KITTITAS COUNTY COMMUNITY DEVELOPMENT SERVICES

July 16, 2010

RE: G & M Parker Short Plat (SP-10-00005)

The Kittitas County Community Development Services Department has determined that the G & M Parker Short Plat (SP-10-00005) is a complete application and hereby grants *conditional preliminary approval* subject to the following conditions:

SP-10-XXX

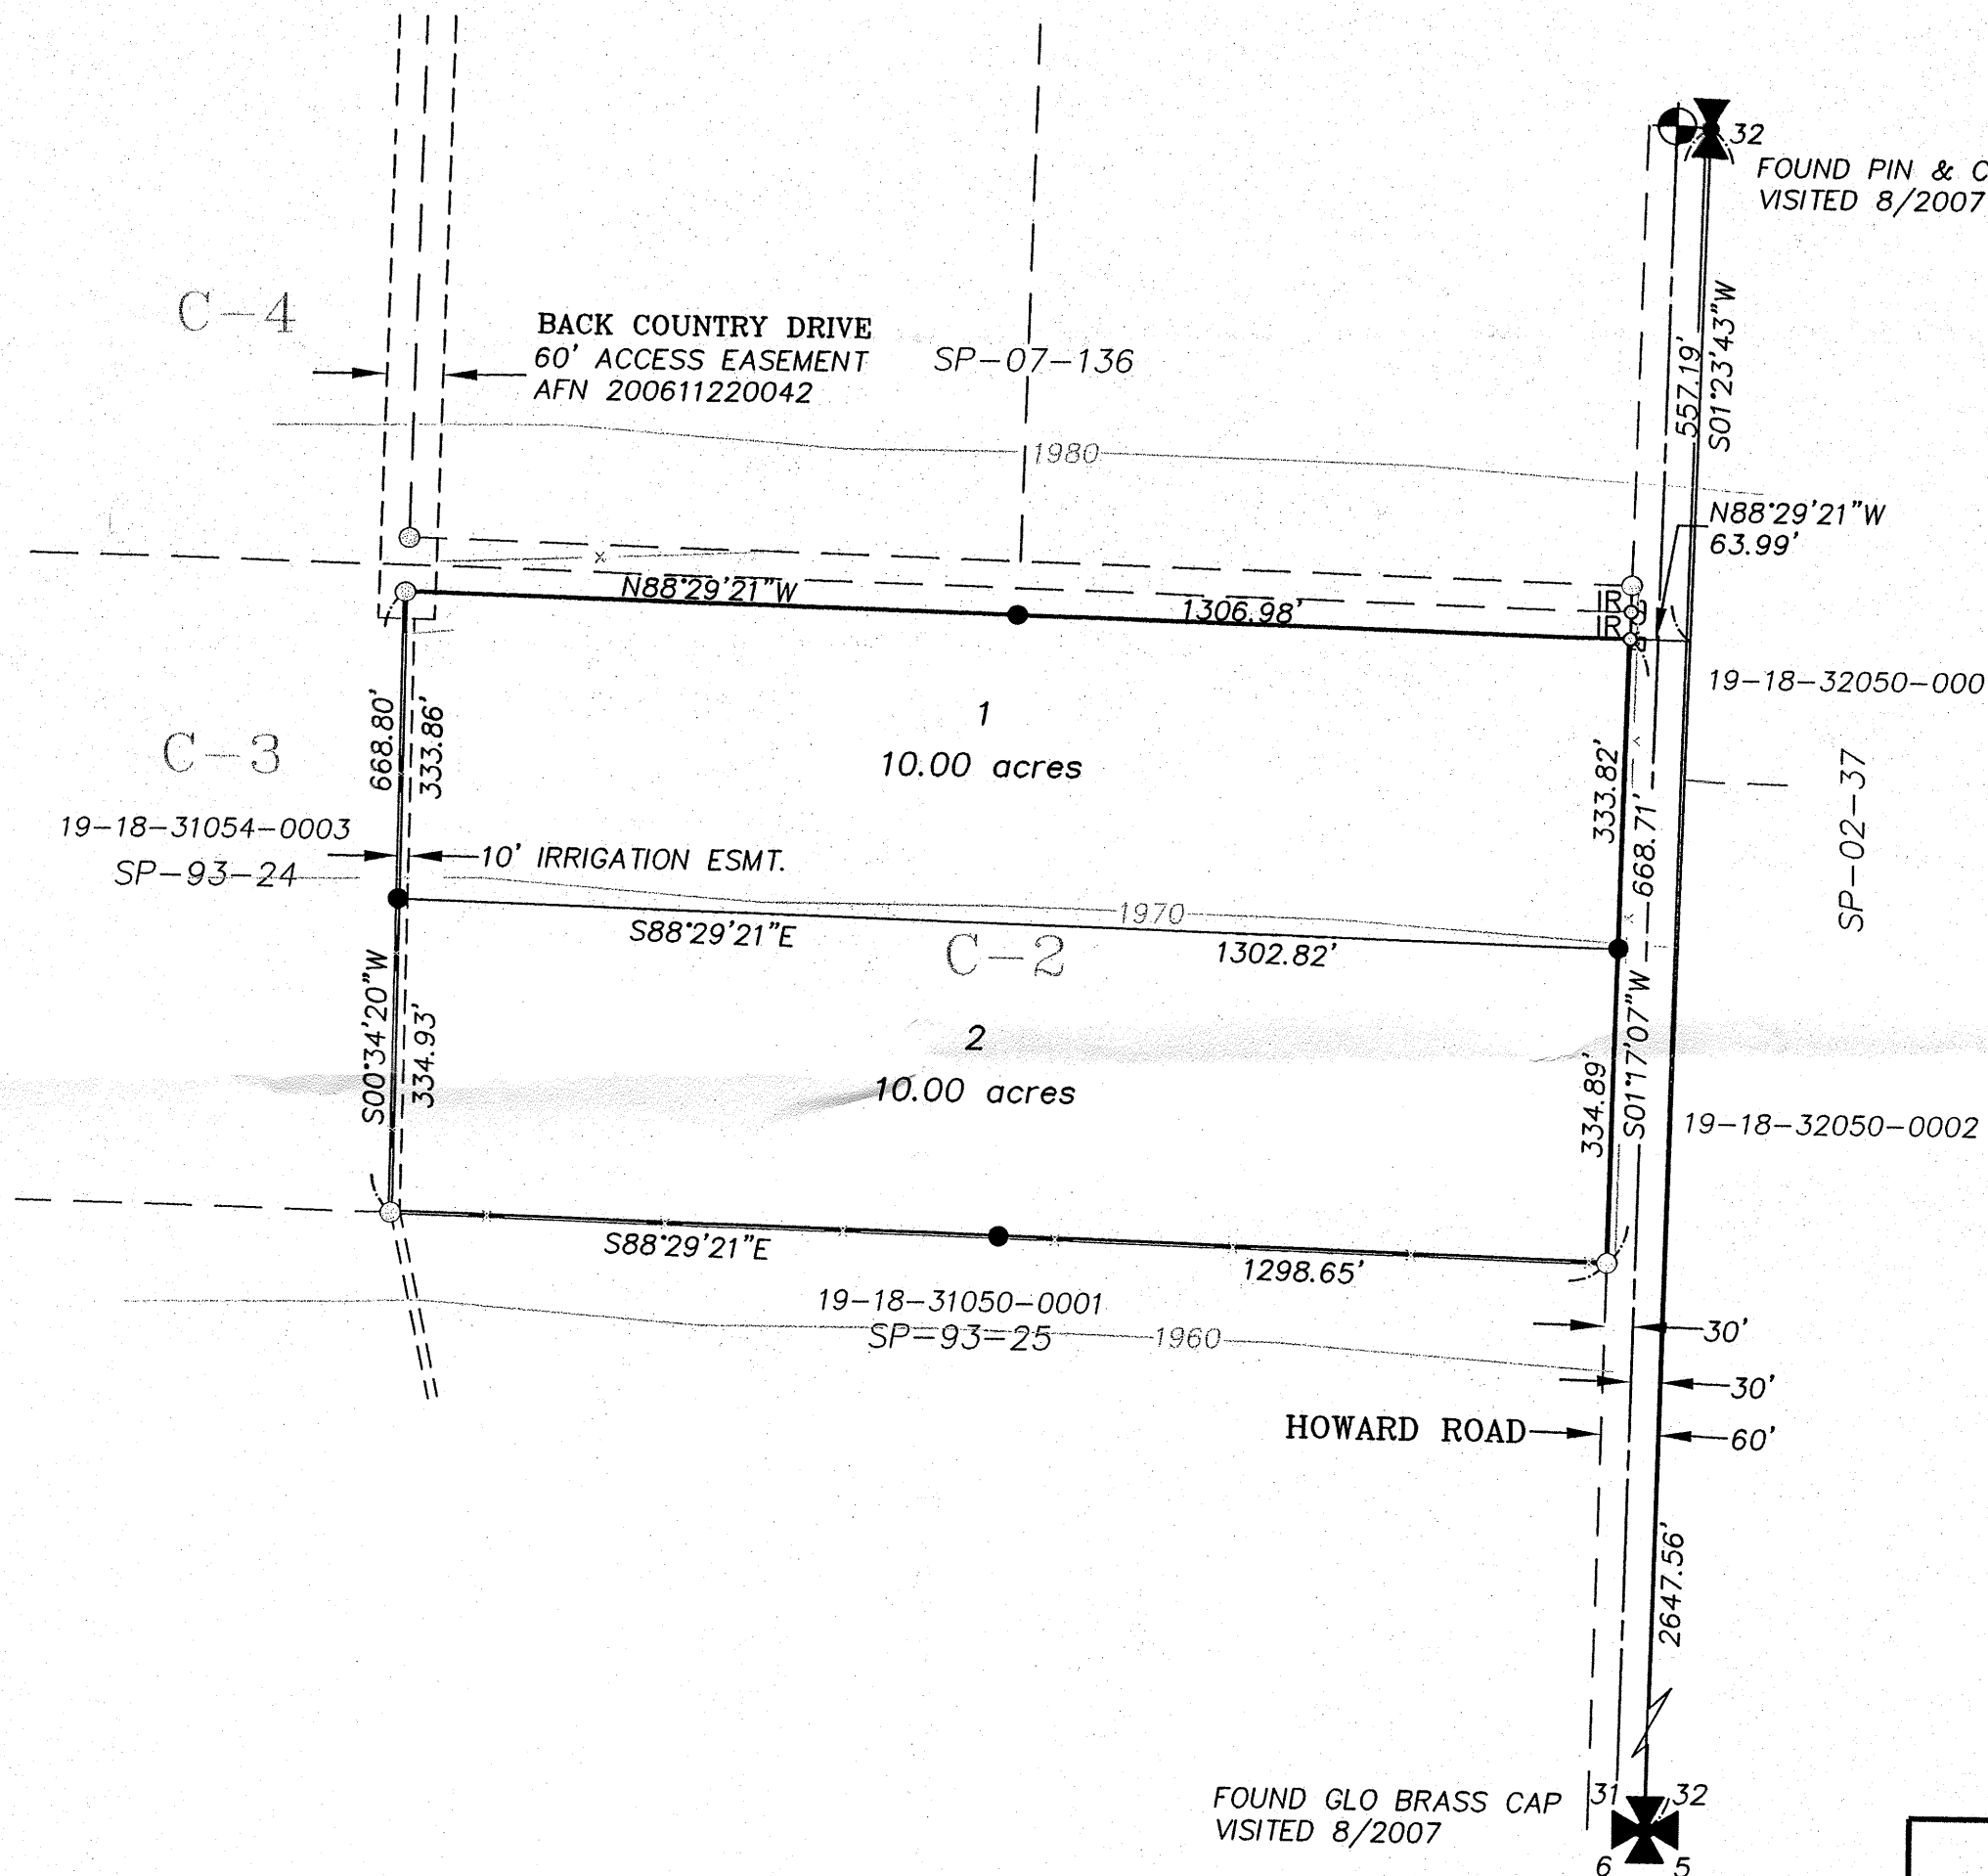
1. Both sheets of the final mylars shall reflect short plat number SP-10-00005 and an accurate legal description shall be shown on the face of the final plat.

6. Individual wells are required to have a 50 foot setback from neighboring property lines (KCC 17A.08.025). Please see the comments from Kittitas County Public Health Department for further information and requirements.
